Potential Mixed Use Development New Veterinary Surgery

At Riverside Works, Woodhead Road, Honley HD9 6PW
On Behalf of Donaldson's Vets Ltd

Supporting Statement:
Response to LA Planning Consultation in relation to Design Matters

Document Ref: C1098 451	Revision Number: 0		
	Initial Issue		
Author:	Kevin Dawson		
Position:	Director		
Date of Issue:	15 April 2025		
Notes:

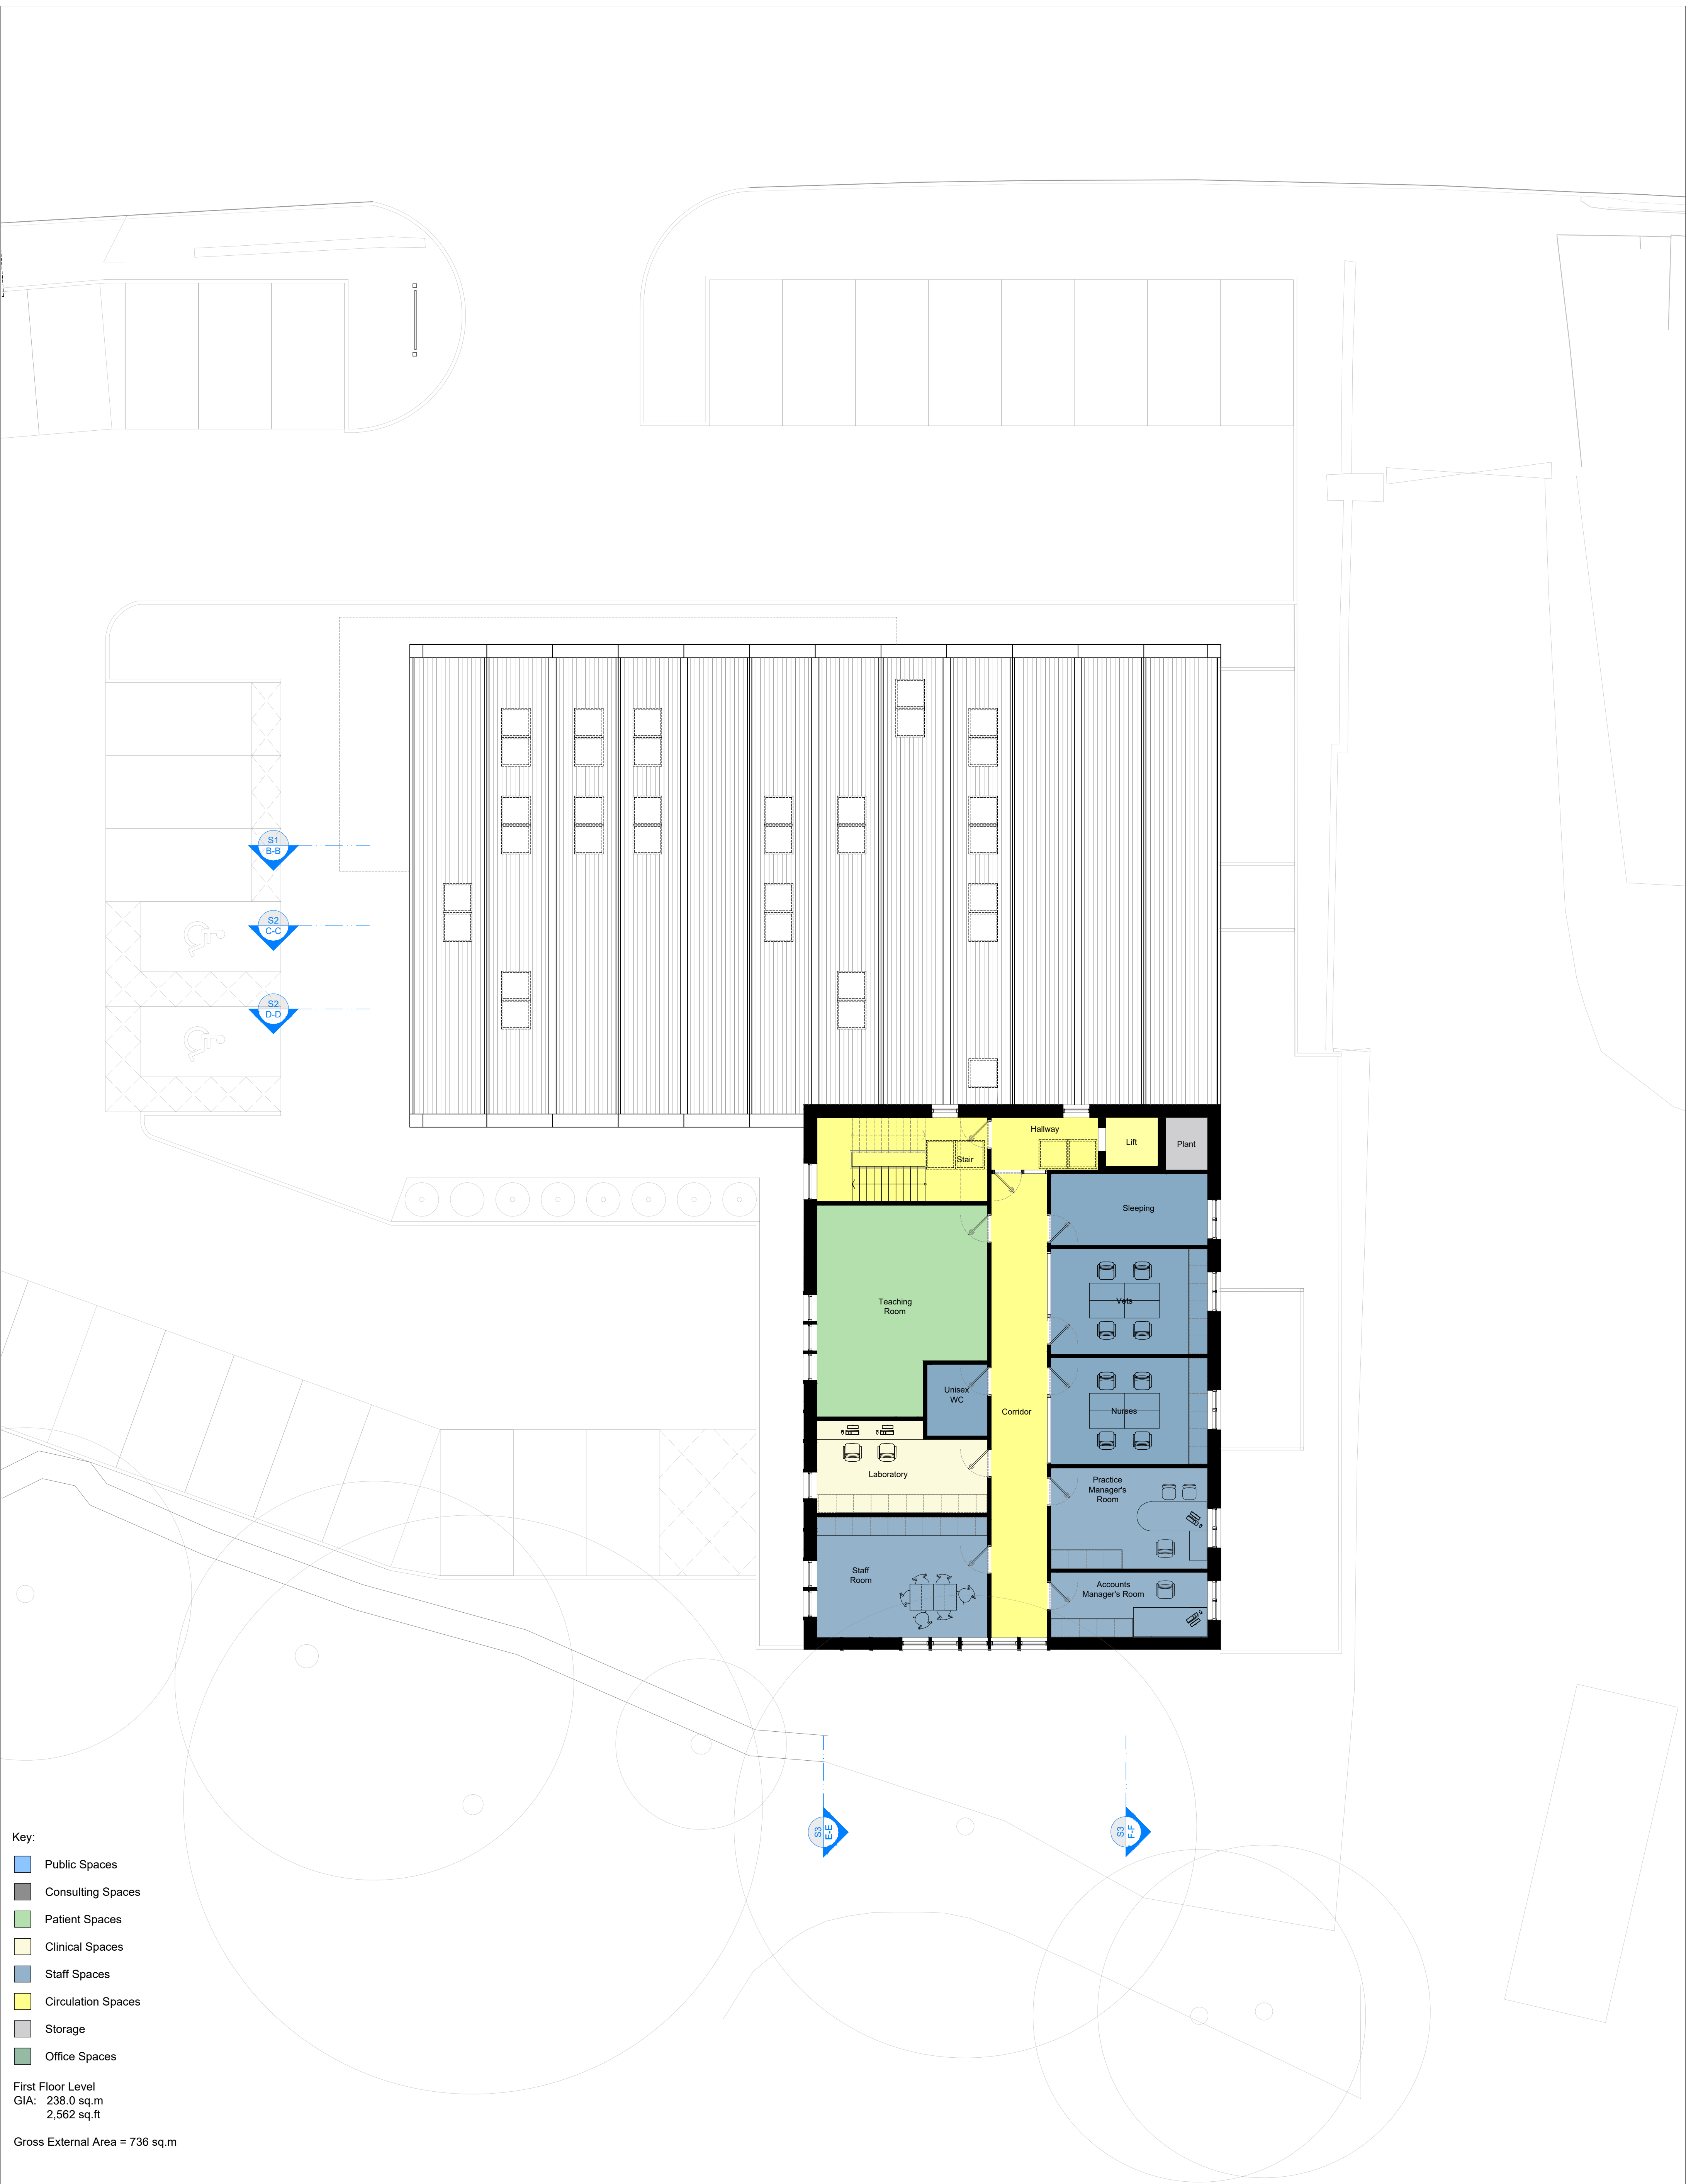
The front elevation of the single storey section is the 'primary' frontage of the building and is considered to be lacking in aesthetic qualities.

Ultimately, this elevation needs to be an attractive feature in its own right. Consideration should be given to enhancing the design of this elevation, in the form of fenestration, to achieve an attractive and active frontage to the building.

The elevation facing onto Woodhead Road and Waiting Area plan have been redesigned to create a more active frontage than the original submission by increasing the amount of glazing and creating a glazed corner at the southern most point of the building.
- 3

The entrance (facing south) is positioned as the returning section of the glazed corner (item 2) within a subtractive run of panelling linked to a projecting canopy which reaches into the car park and provides shelter on the approach.
- 4

There is a need for the elevation to be more solid opposite the car parking spaces to the north of the site entrance due to the privacy which is required in a veterinary consulting room. Glazed panels are to be formed in strategic locations offering visual connection from circulation spaces to the inside and outside.
